# CITY OF ALBUQUERQUE

RE: **ABQ Ride Daytona Transit Facility**  
**Grading and Drainage Plan (Engineer's Stamp Date: 6/14/17)**  
**Coversheet Stamp Date: 6/1/17**  
**Hydrology File: J09D025**

Based on the information provided in your submittal received on 6/23/17, the Grading and Drainage Plan cannot be approved for Building Permit until the following comments are addressed:

DAYTONA - STORM CAD RESULTS

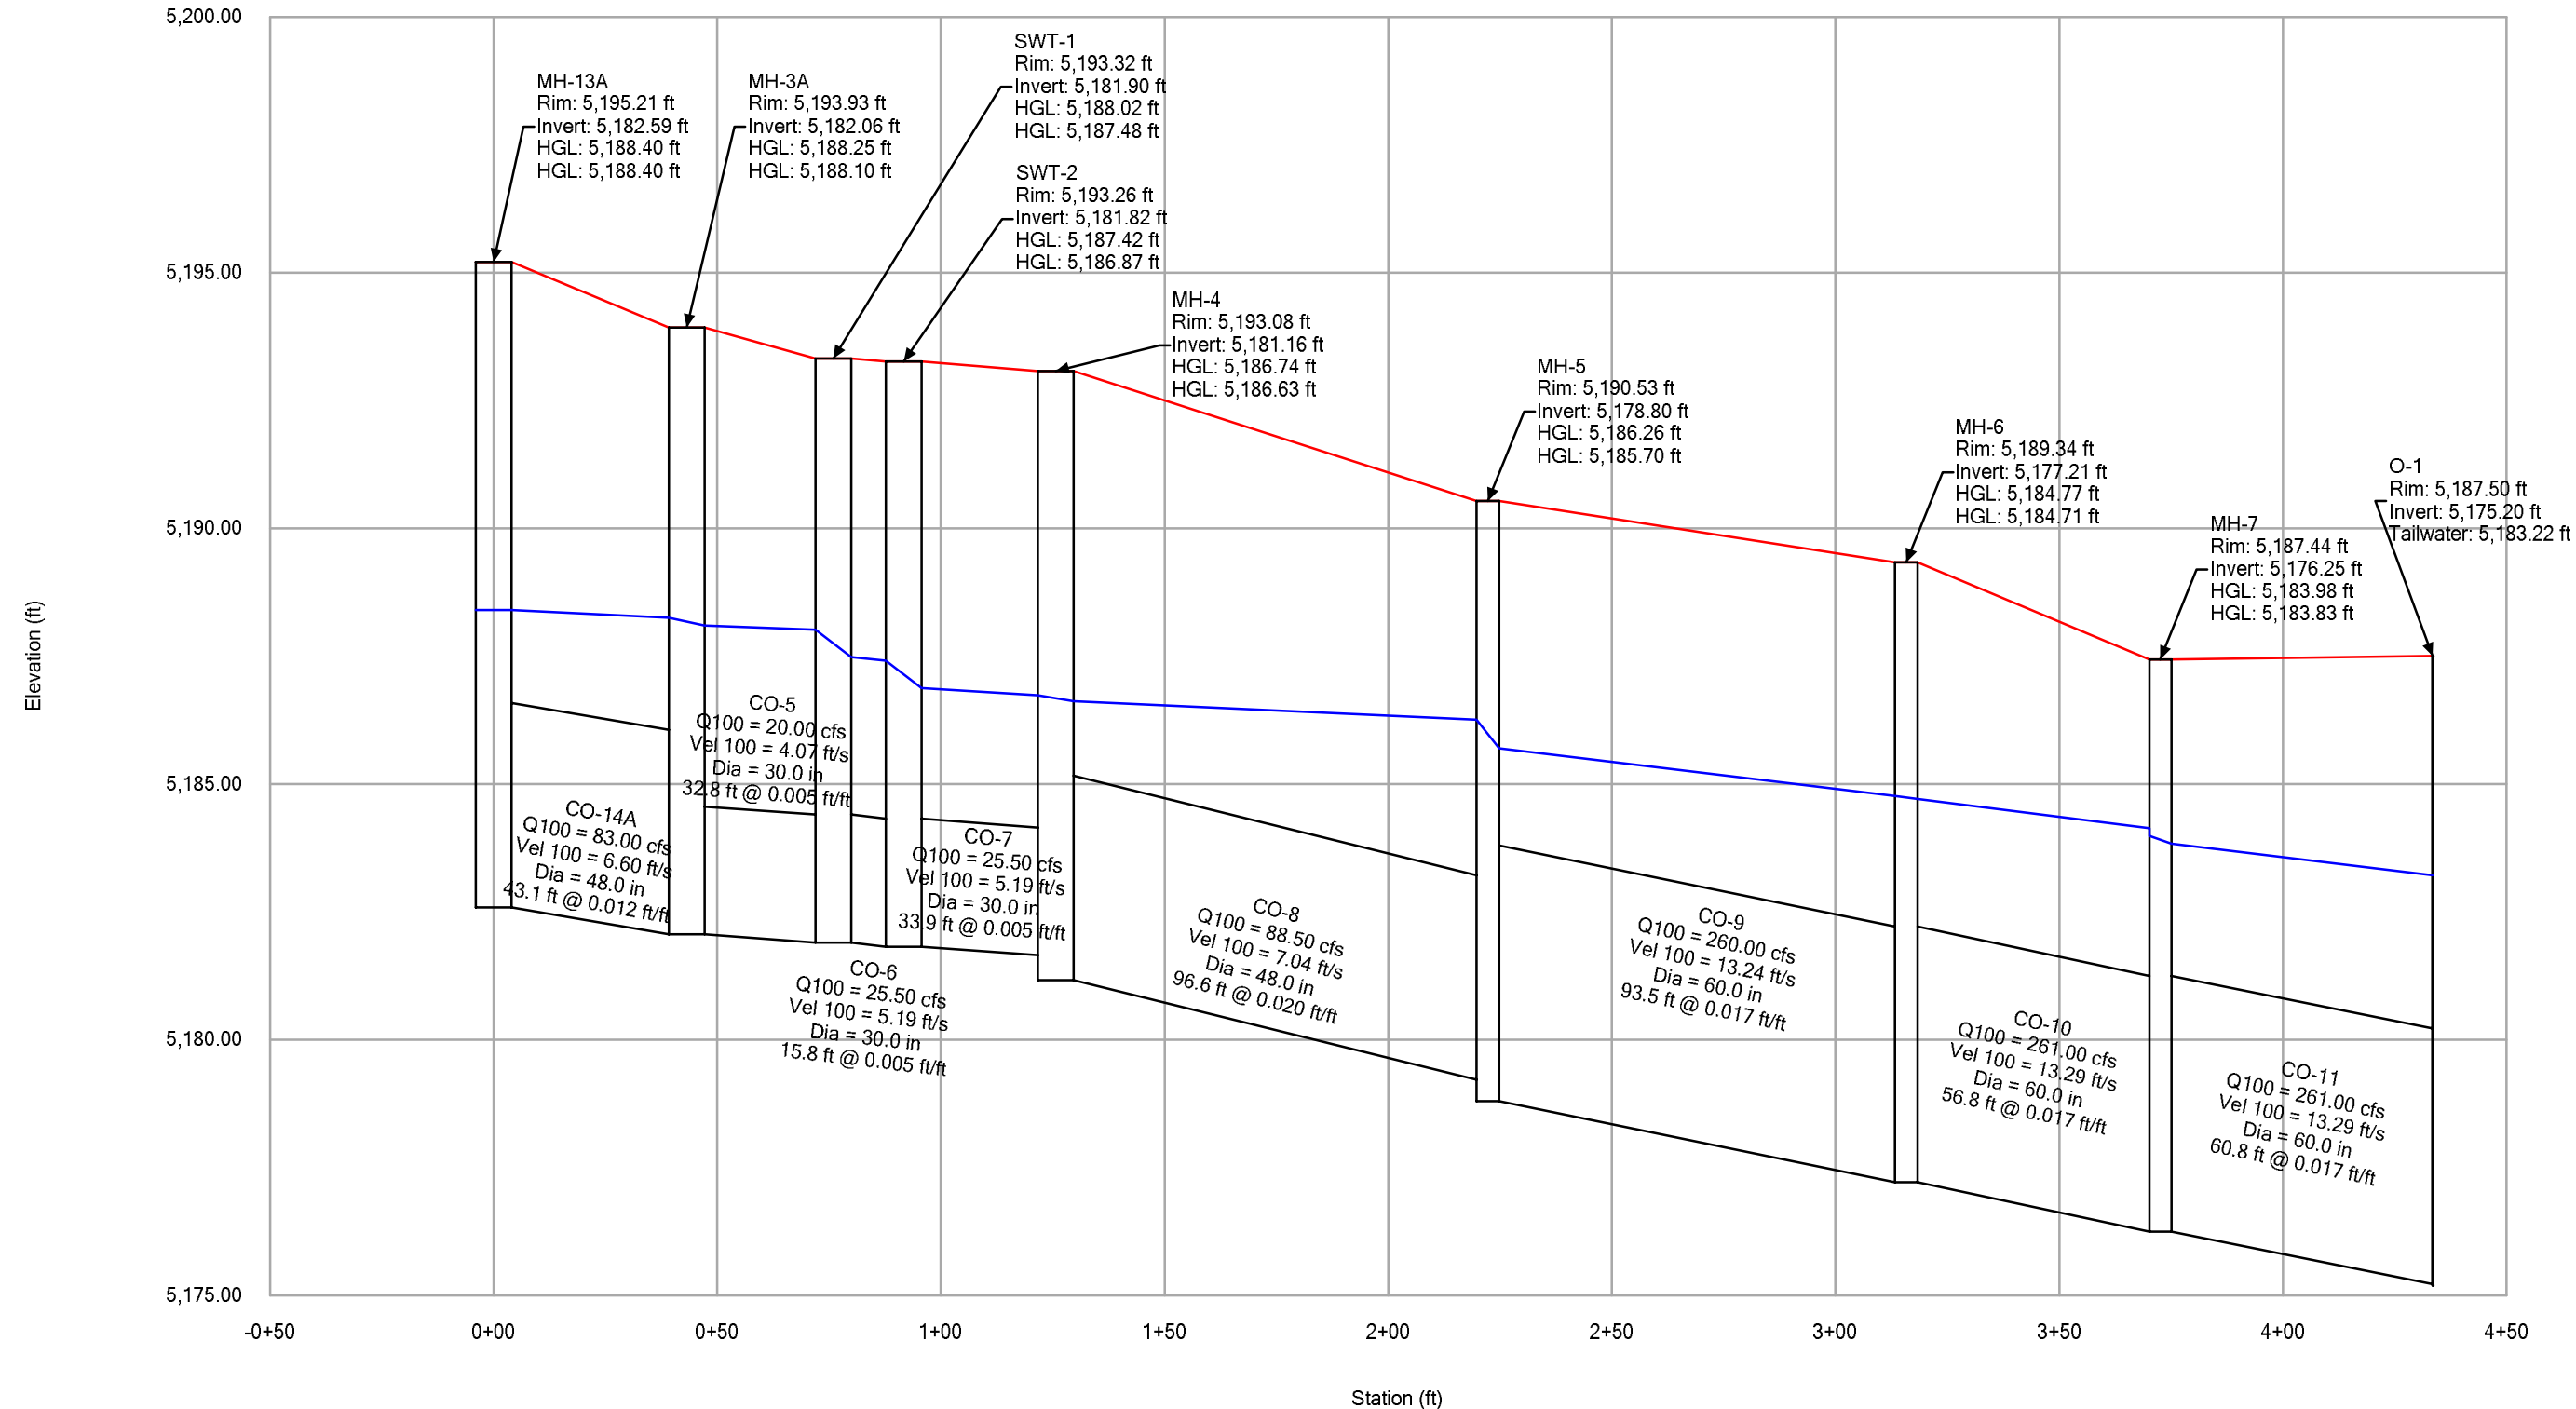
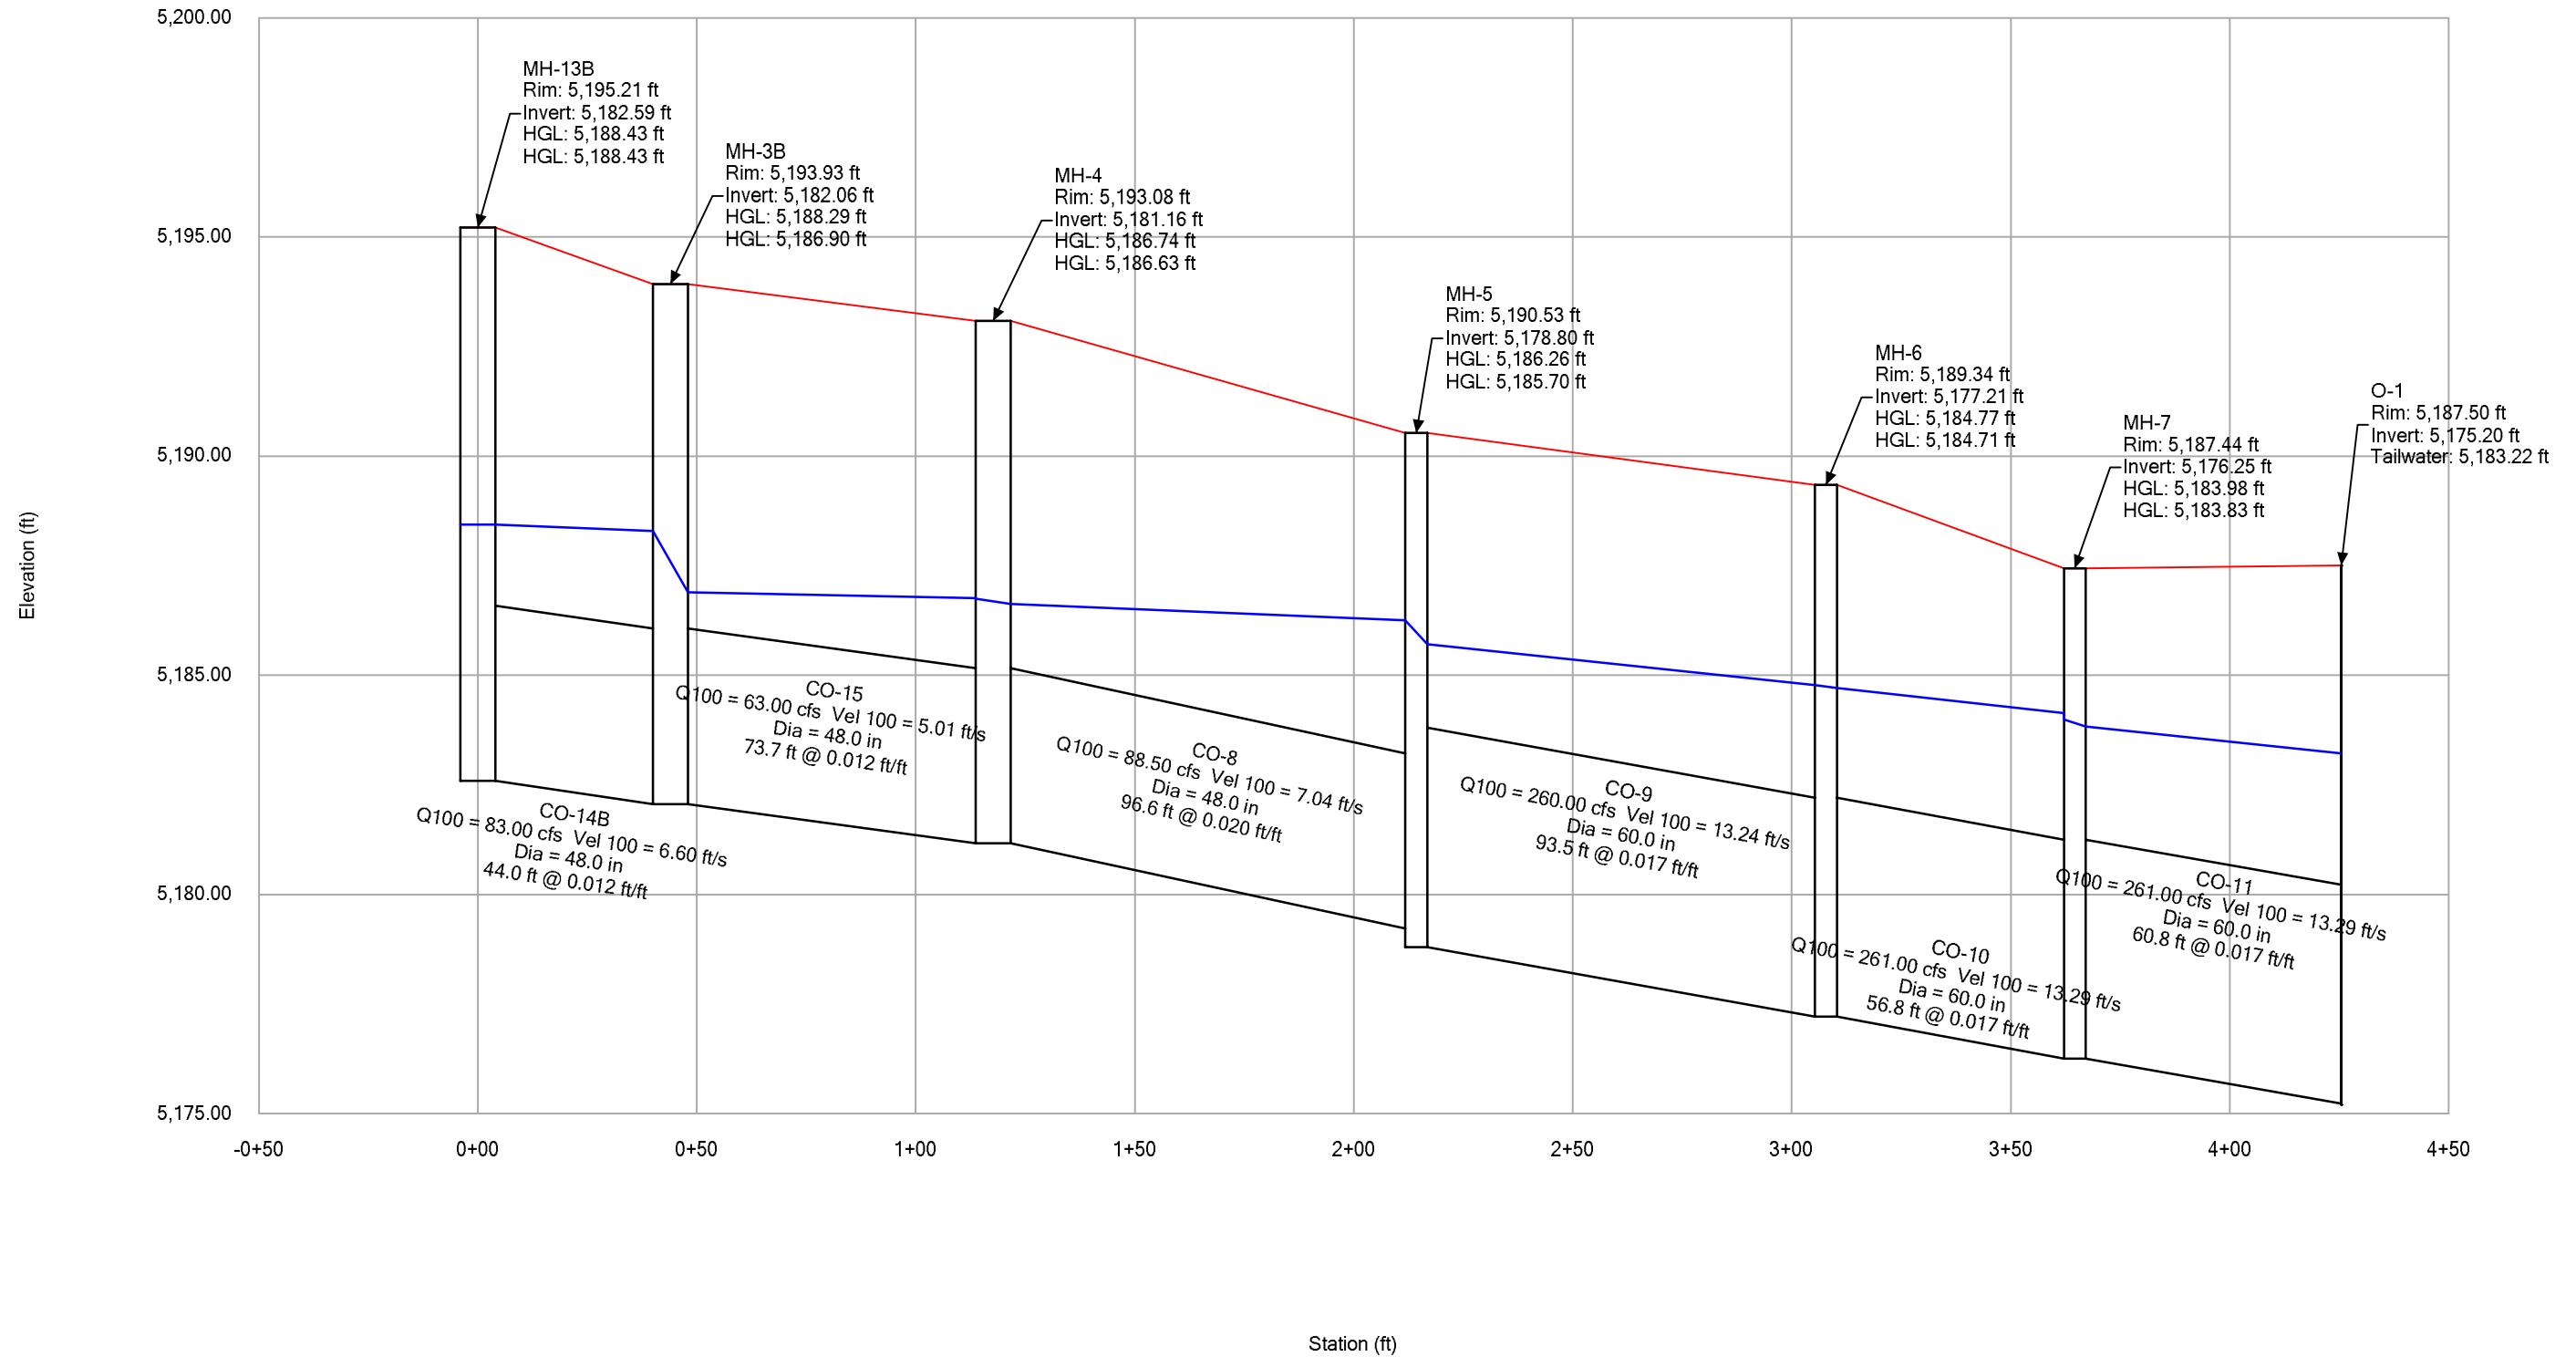
3. Pipe profiles and supporting data need to be included: flow (100yr), velocity, HGL, and junction losses through the various manholes and water quality features.
